# Response from Newark and Sherwood District Council as Planning Authority

A46 Newark Bypass

Inspectorate's reference number TR010065

Photomontage 25: Year 15 in operation (planar projection, field of view 39.6 degrees x 27 degrees, to be viewed at A3)

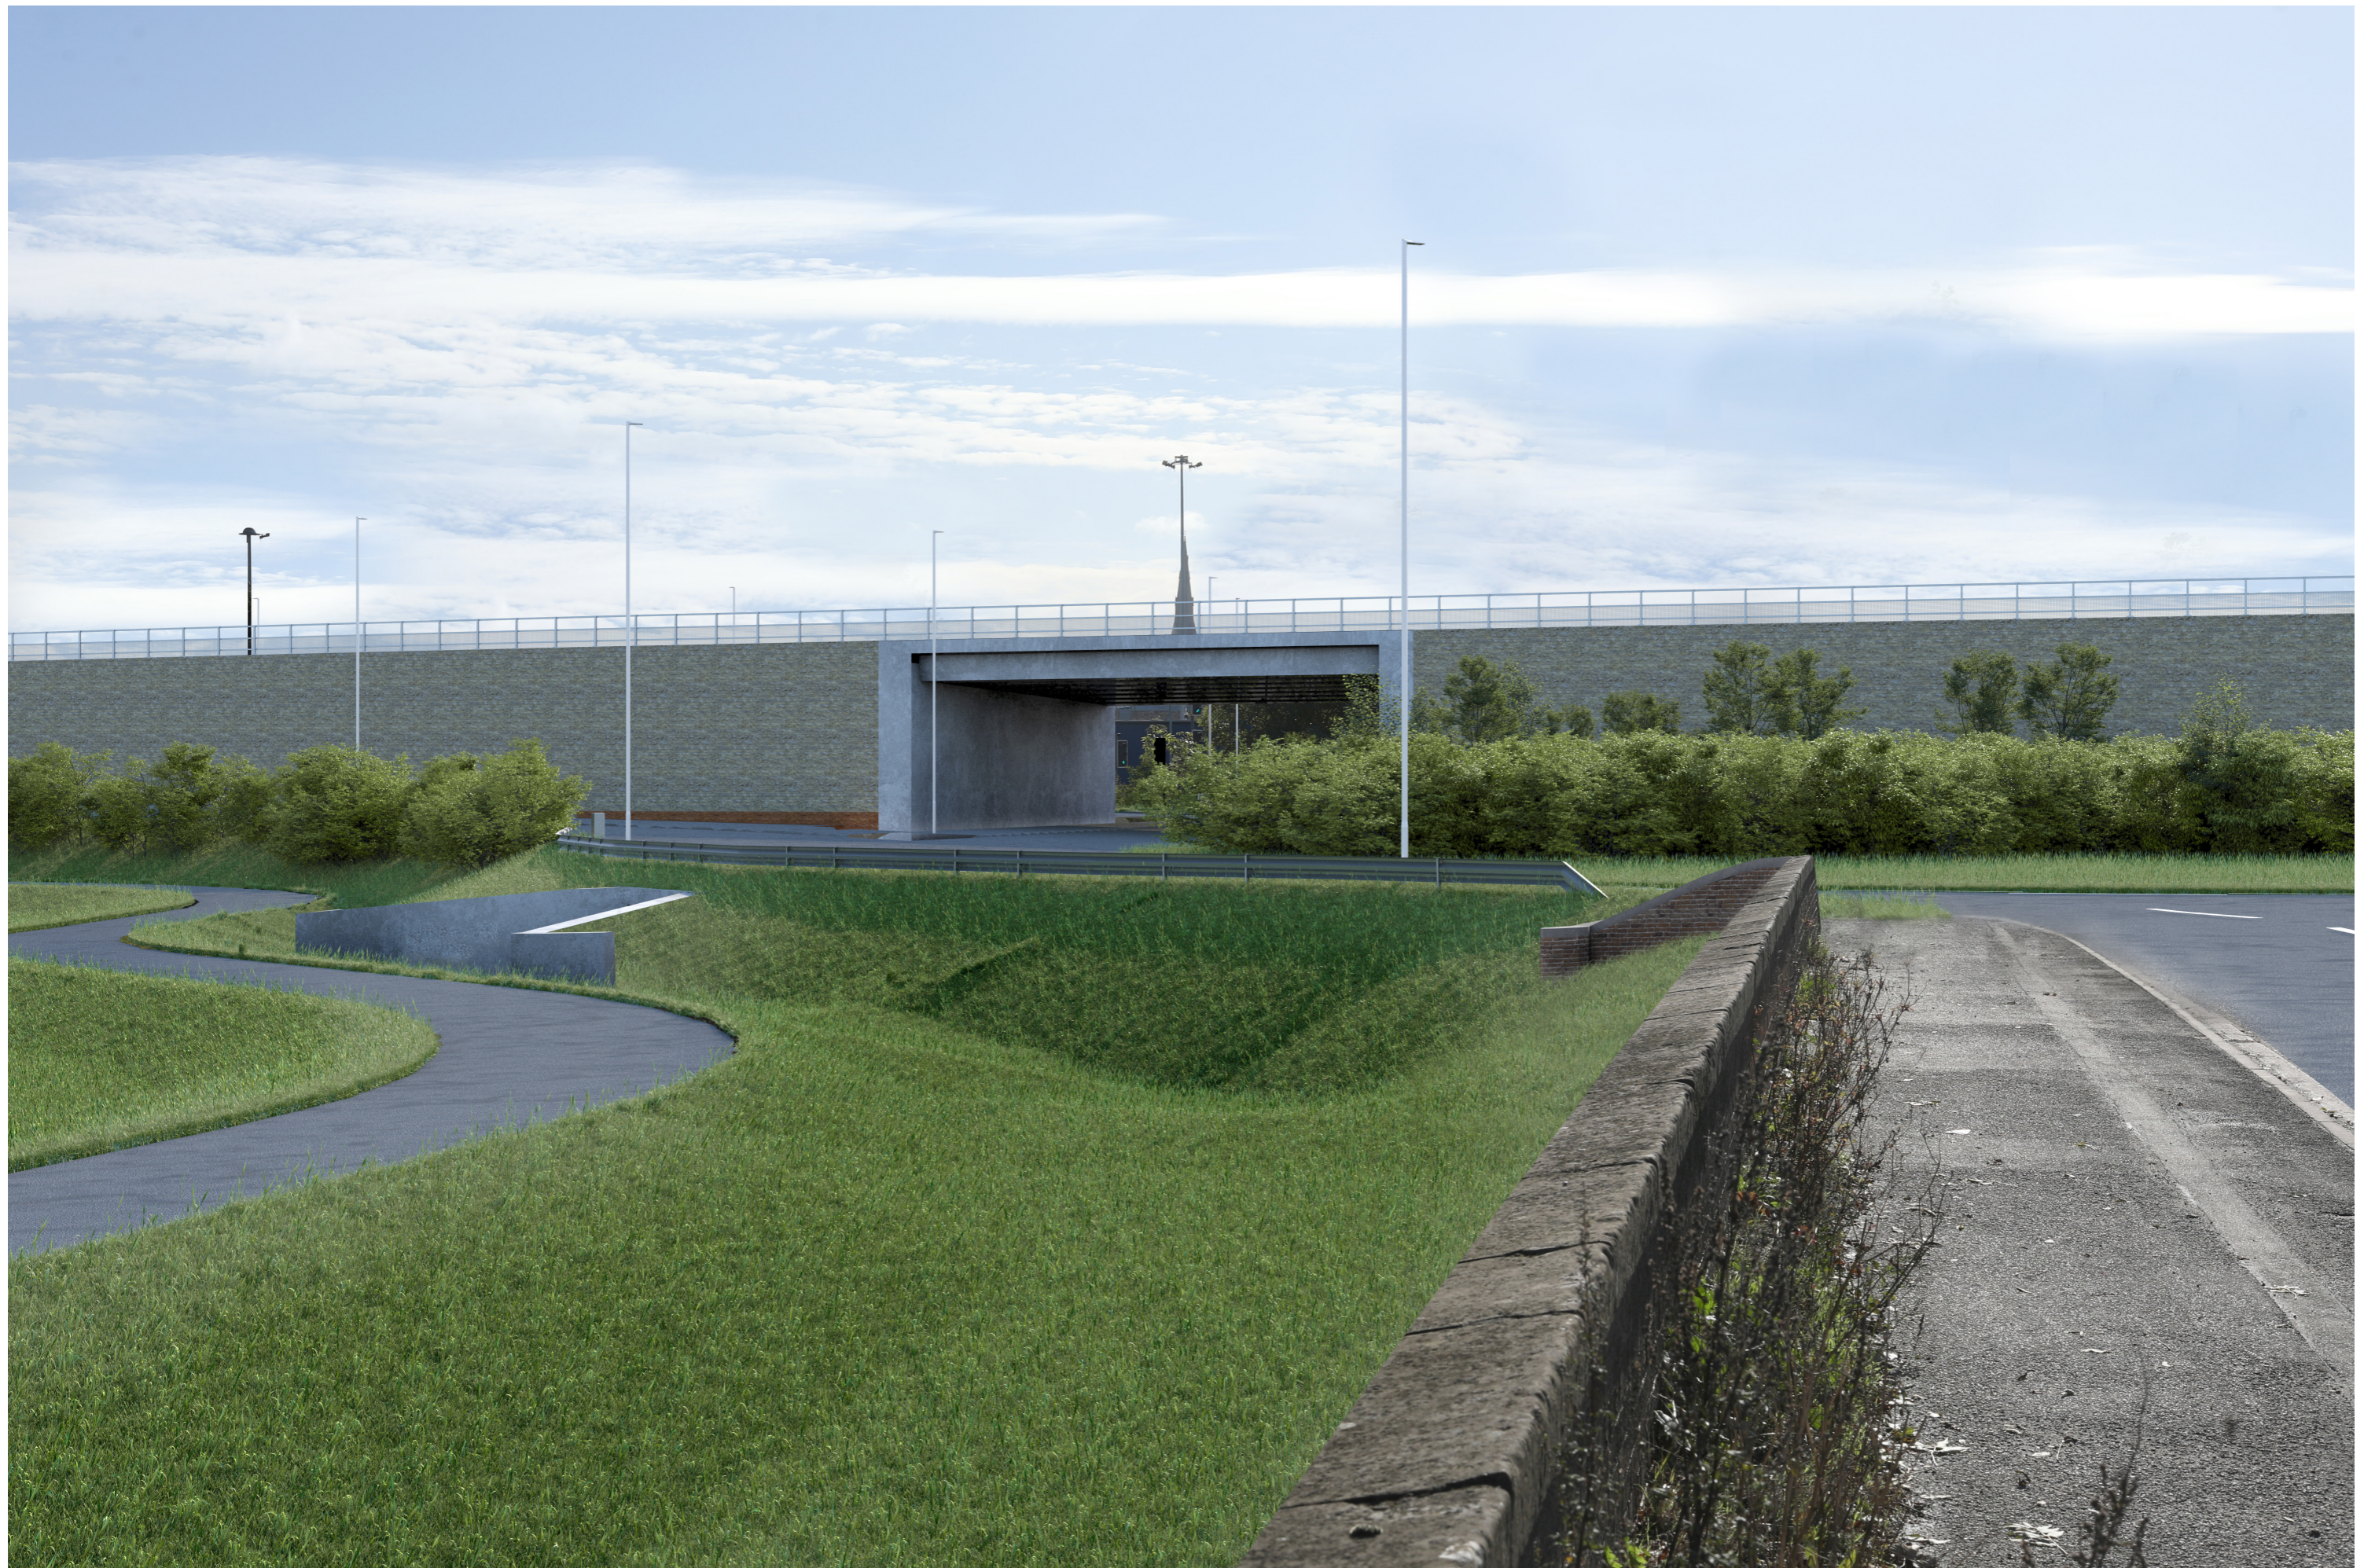
- Compliance with relevant legislation;
- Policy compliance and planning balance;
- Cultural Heritage – Built heritage - Although there is a visual receptor (no.25) in relation to Smeaton’s Arches, which is Grade II Listed, has not been identified as an important receptor. Due to the significance of the Smeaton arches, the significant historic approach along Great North Road into Newark, along with views of grade I listed St Marys Magdalene, this should be a ‘Key Visual Receptor and Photomontage’. This will allow for a full assessment on the potential impact of the engineering works will have on the setting of the listed building and historic route into Newark. In addition, it is considered that the visual receptors do not allow for a full assessment on potential impacts on Winthorpe Conservation Area. An additional visual receptor may be required or the existing (no. 41 & 43) may need to be wider than the 90 degrees shown. There are elevation plans for each bridge, however nothing showing the full length of the cattle market bridge from where it rises at Kelham Road to where it falls to the east. In addition, a full elevation of the bridge over the A1;
